From: Sue Howell
Sent: 10 September 2019 15:37
To: Planning.Responses <Planning.Responses@arun.gov.uk>
Cc: Simon Davis <Simon.Davis@arun.gov.uk>
Subject: RE: Planning Consultation on AW/159/19/DOC

Comment from Greenspace

APPLICATION NO: AW/159/19/DOC

Site Address: 261 Aldwick Road Aldwick PO21 3QU

Site Plan

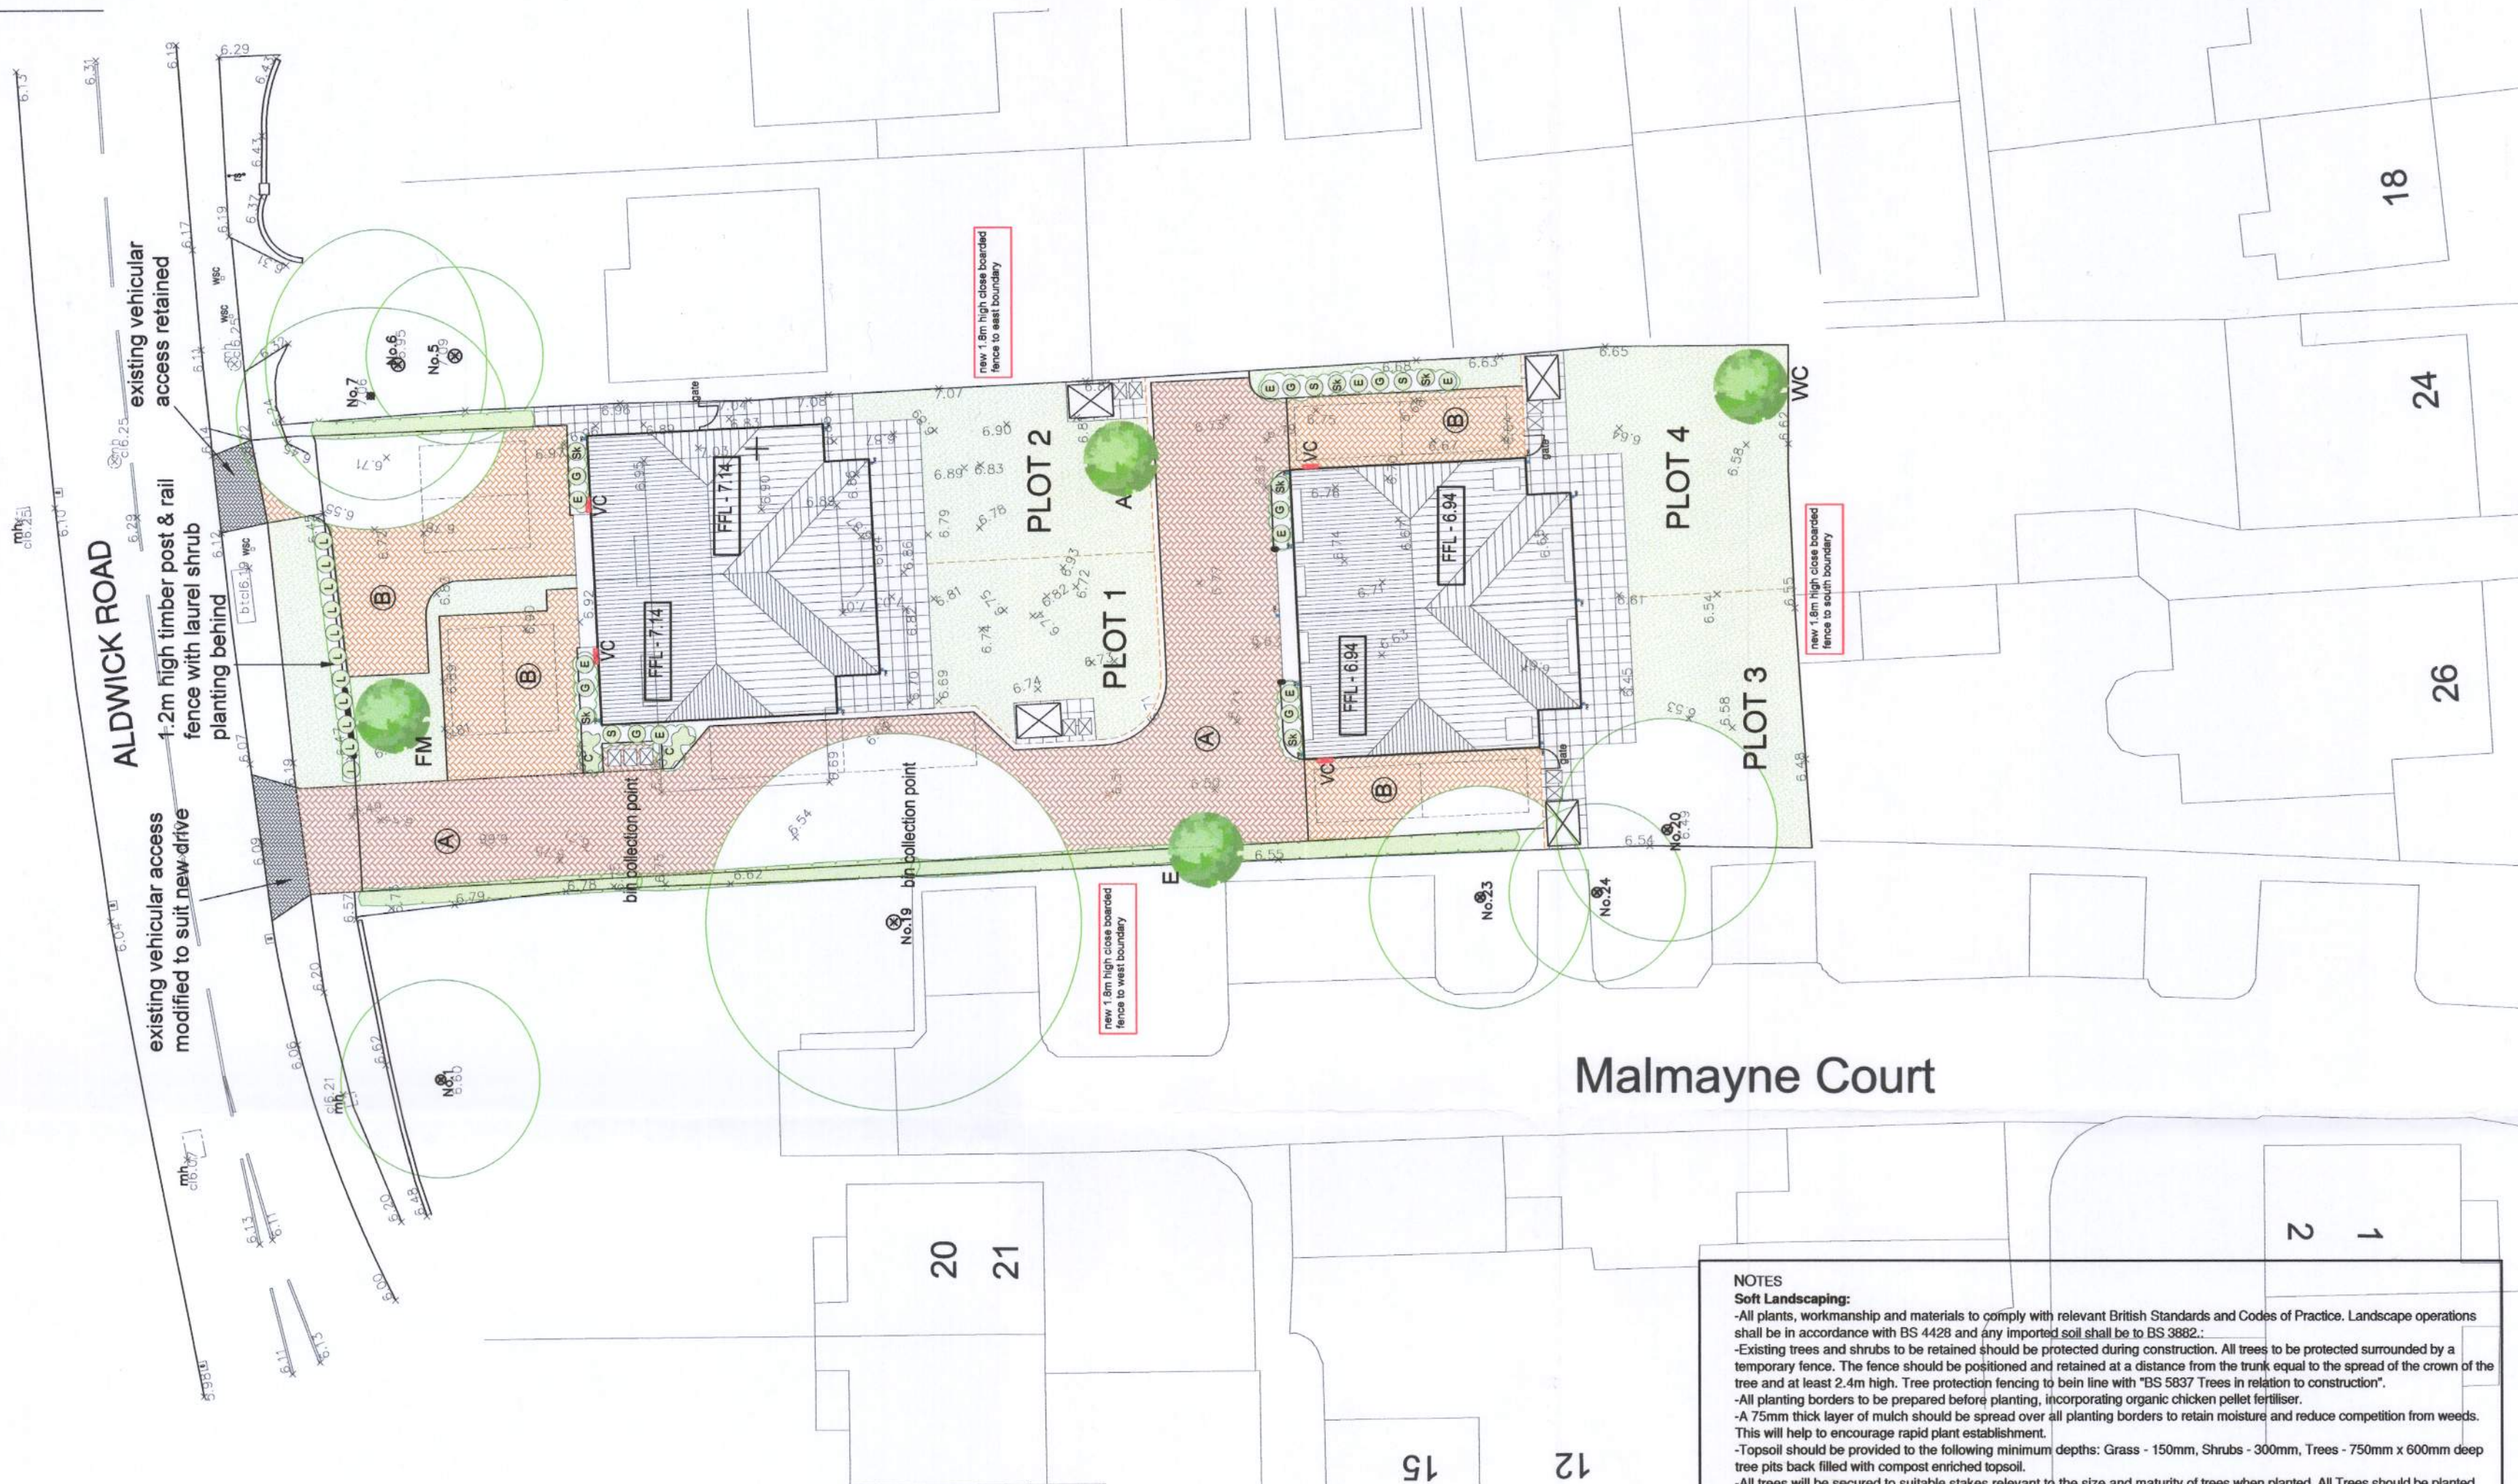
Further to submission of Site Plan dwg no 200, which contains a suitably proposed landscape scheme in terms of species choice, planting density and size at time of planting. **Please request from the applicant for clarity the actual quantity of the planting and hedgerow numbers being proposed** (both laurel and native hedgerow) Once these quantities are confirmed I see no reason not to recommend the discharge of Condition 8 on application AW/159/19/DOC.
